From: [REDACTED]
Sent: [REDACTED]
To: Sian Eggington
Subject: FW: Attn Sian Eggington Request for further information AB/125/20/L
Attachments: We sent you safe versions of your files; Actual Floor plan 19 Maltravers Street.pdf; Actual floorplan only.xlsx

From: Iqraa Malik <[REDACTED]>
Sent: 24 November [REDACTED]
To: Chris Hawkins <[REDACTED]>
Cc: Sian Eggington <[REDACTED]>
Subject: RE: Attn Sian Eggington Request for further information AB/125/20/L

Unfortunately your application is still invalid for the following reasons:

SCALE 1 to 100 existing

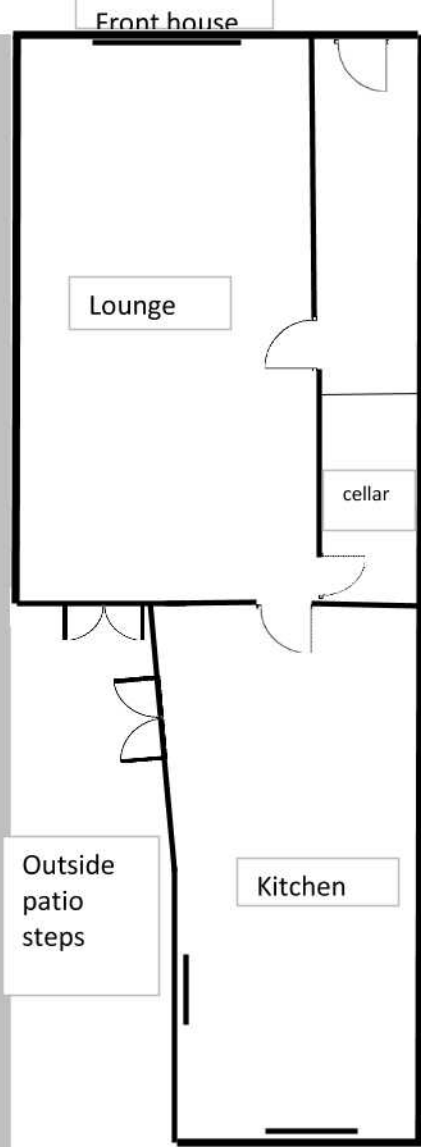
Could you please confirm the scale as I'm measuring it at 1:100 and this is what it's showing it as. As the drawing is scaled 1:100, 1cm= 1:100 so if the proposed extension is for example 1.8m by 3.6m it would be shown as 1.6cm x 1.4cm

The measurements on this new plan appear to be the same as the old?

No worries. I've had a quick look over the floor plan and it doesn't measure to the 1:100 scale listed on the plan. I've attached a screenshot below. Please amend.

Please add room labels to your floor plans so we are able to process and validate this application.

Floor Plans: Please add room labels.

The extension is 360cm which is 3.6cm at 1:100 by 184cm which Ive done at 1.8cm

The measurements attached are exactly what excel is showing ie 3.6 cm and 1.8cm across for the extension.

19, Maltravers Street, Arundel, West Sussex, BN18 9AP
Scale 1:200

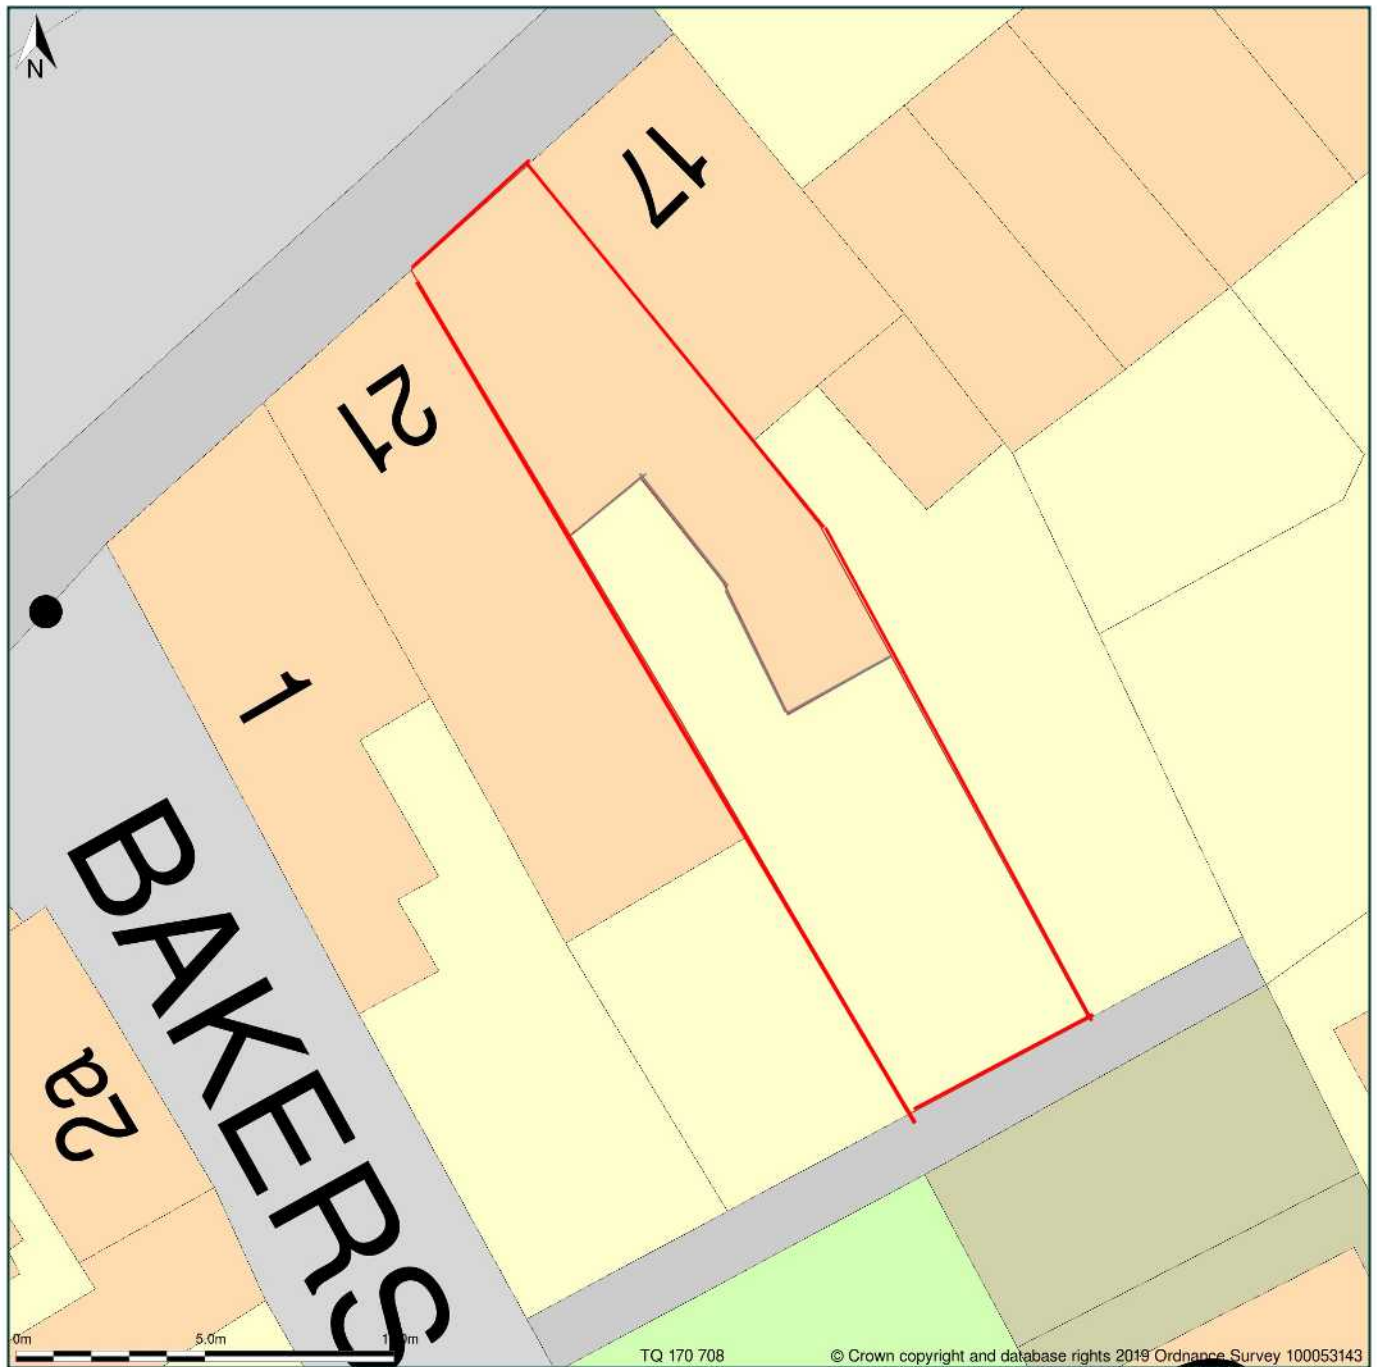
Block Plan: The red line on this must match the one on the location plan, please amend.

Block Plan: This must also be in PDF format with dimensions from the proposed extension to the site boundaries. Please amend.

The company I used sent me the location plans with the house boundary also in red. Ive managed to get that changed as per your instructions and I hope they are correct now.

Elevation of external kitchen door removal
Scale 1:50
Current side elevated view

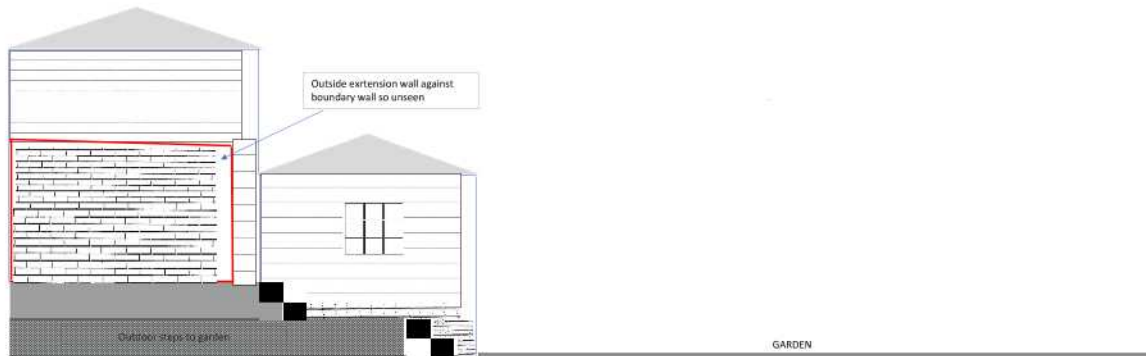
Elevations: We will also require the side elevation where you'll be removing the door.
